**Subject:        *Edward Mills Property – 5236 W Mercer Way  
Wetland Delineation Professional Opinion Concurrence Letter***

This professional opinion concurrence letter provides a brief summary of our review of the wetland delineation and rating conducted by Red Wing Environmental at 5200 Block West Mercer Way, Mercer Island, Washington 98040 (Tax Parcel Number 192405-9324). PACE's scope includes preparing a professional opinion concurrence letter based on findings from an on-site review of the wetland delineation, conducting an independent review of the wetland rating using the Washington Department of Ecology 2014 rating system, commenting on any differences found in the delineation, data or rating, and commenting on the proposed buffer averaging and mitigation plan.

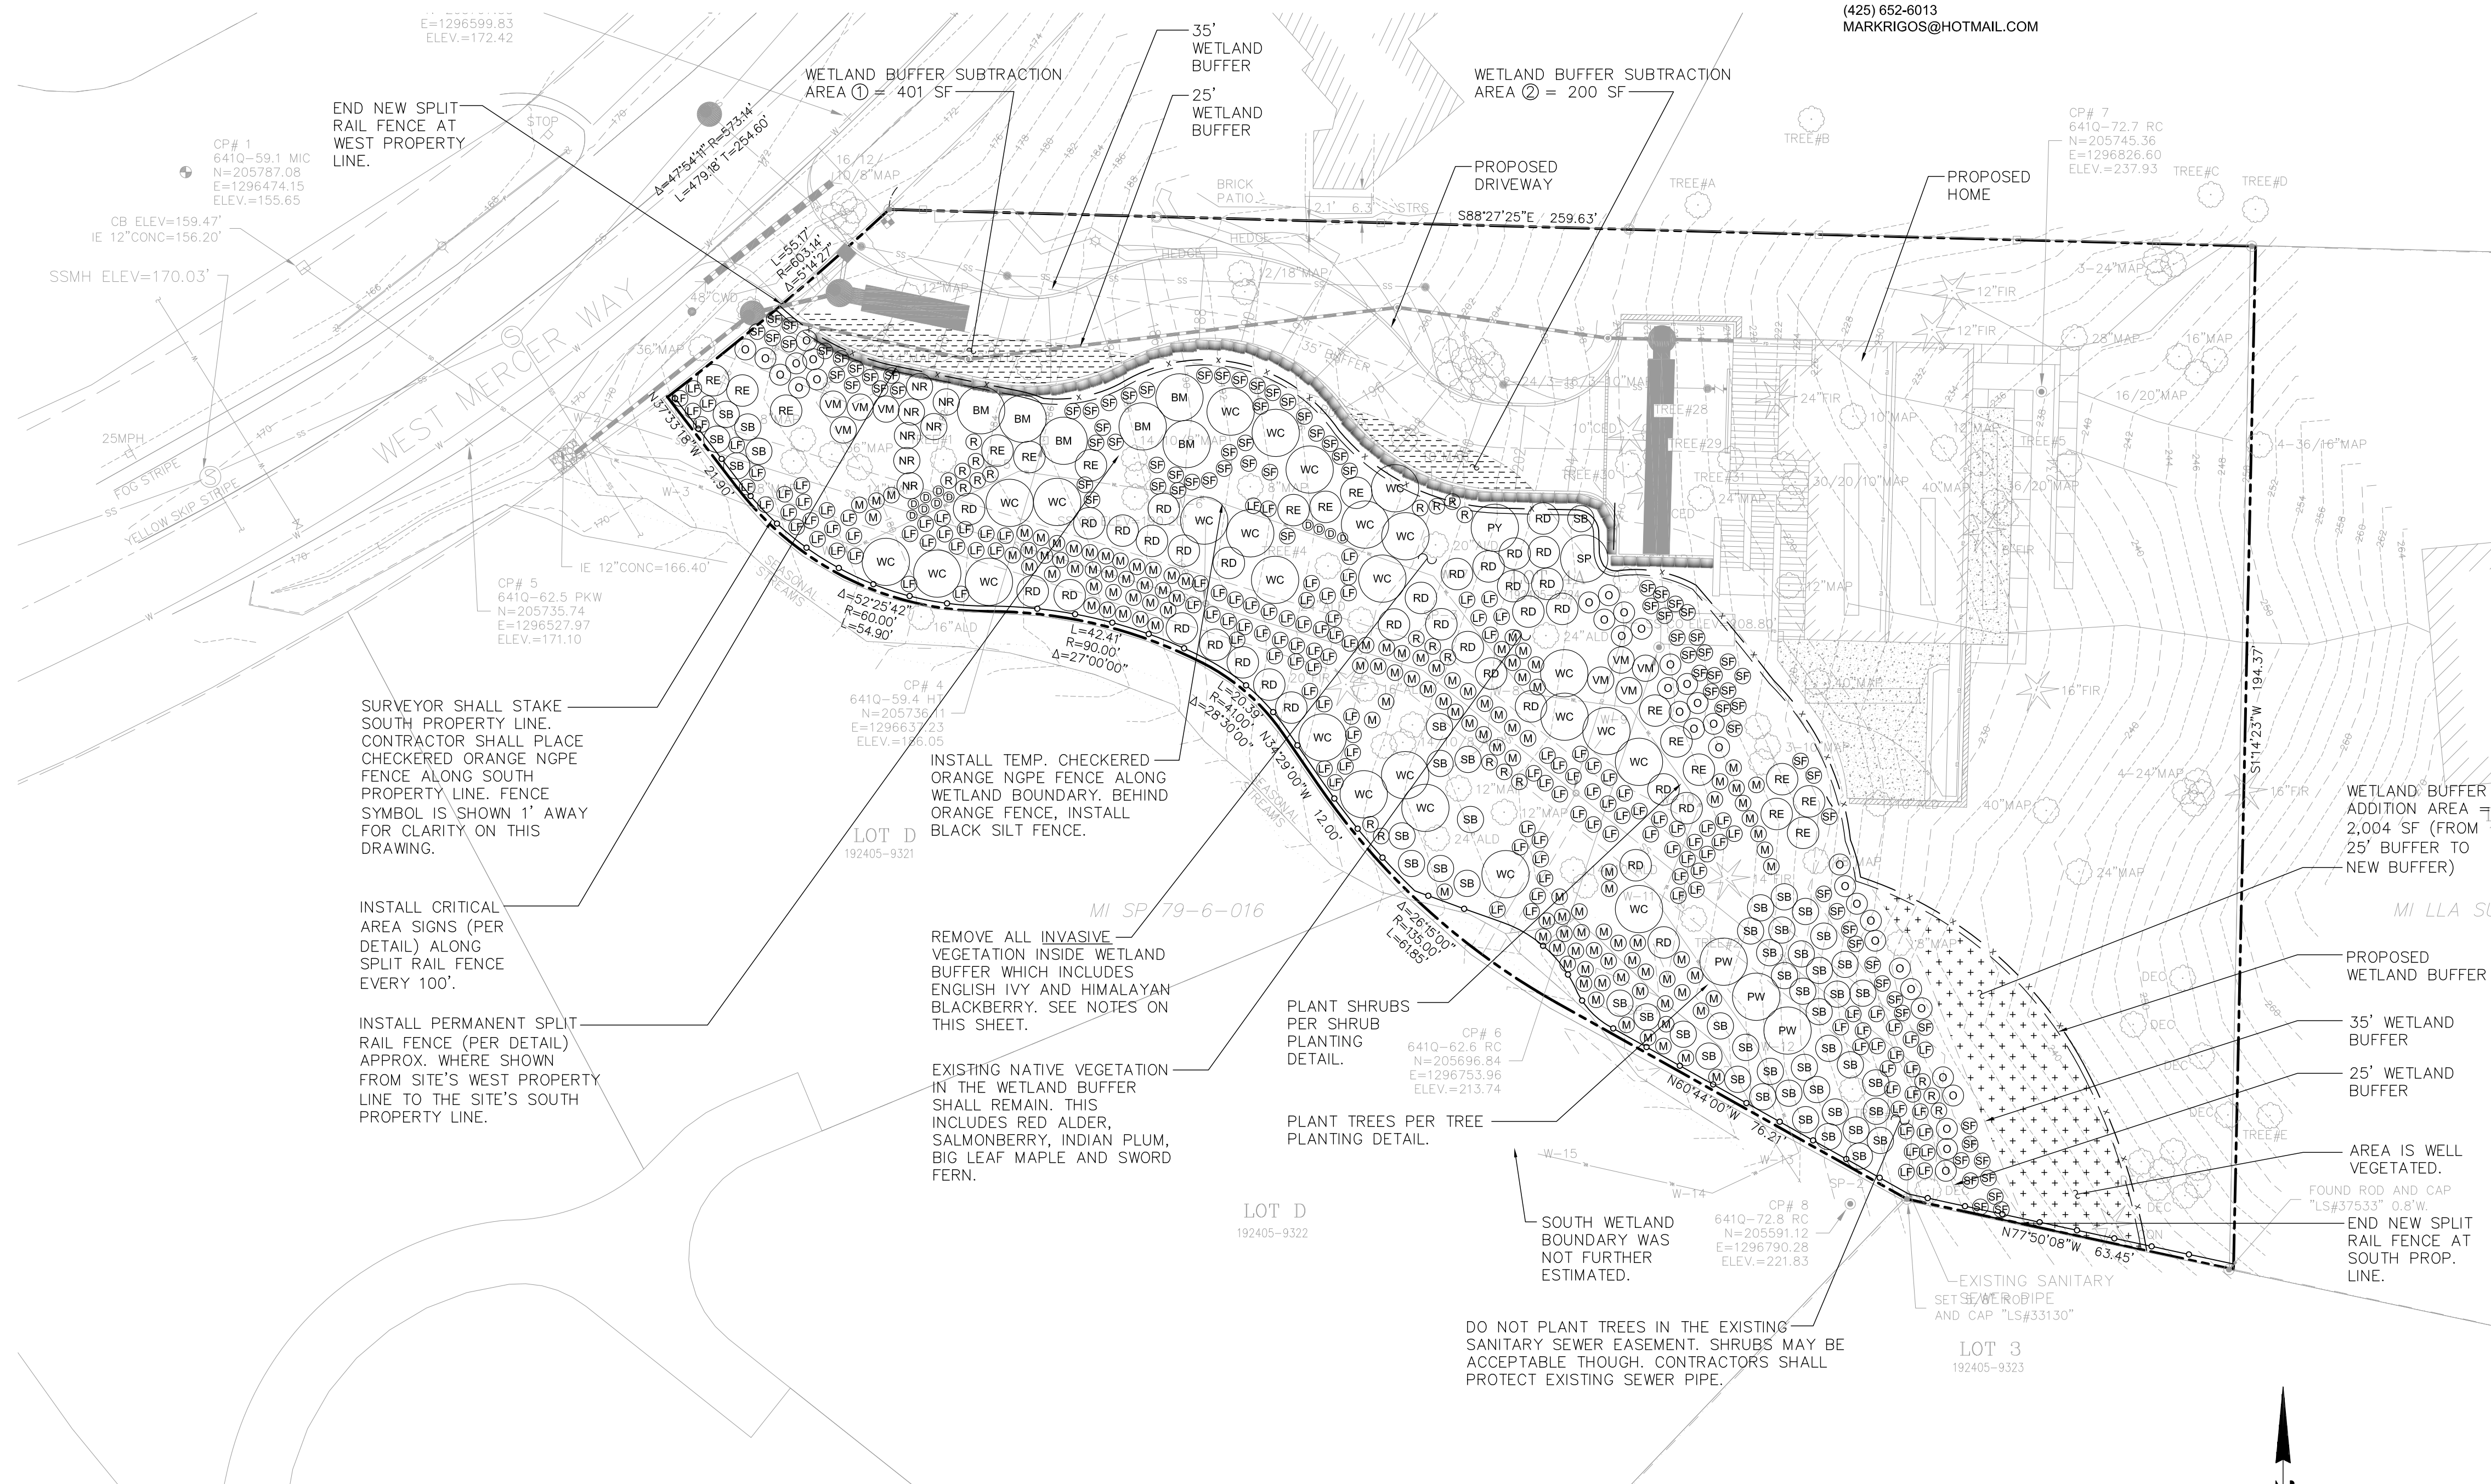
- The mitigation plan should be updated to include labels to better locate the wetland and the wetland buffer.
- The noxious and invasive weed removal areas should include both the entire wetland and buffer areas, to improve the chances of controlling these aggressive invasive non-native plants.

- The mitigation plan should include a table of figures to quantify the areas of buffer impact and the areas proposed for mitigation to provide analysis of no net loss.

- The mitigation plan should include a table of figures to quantify the areas of impact and the areas proposed for mitigation to provide analysis of no net loss.

- The number of plant stock materials should be revised to reflect the additional mitigation areas.
- We don’t recommend planting highly aggressive natives such as soft rush (*Juncus effusus*) because they tend to form monocultures. If site conditions suit them, they will probably move in anyway.

- Existing trees should be better shown to help show where new plantings are proposed and to show that crowding won’t be a problem

- The Critical Areas sign on the plan is for King County.
- On Sheet W1.0, the note stating, “*Area is well vegetated*”, the existing vegetation is not shown or identified.

- On Sheet W1.0, the note stating, “*End new split rail fence at south prop. Line*”, appears to point to the orange checkered NDPE fence.
- The Legend lists temporary shoring, which is not visible on the plan, wetland flags, which are also not visible on the plan, and sample point Flag #s, also not visible on the plan. Recommend that these items be removed from the legend or made visible on the plan sheet.
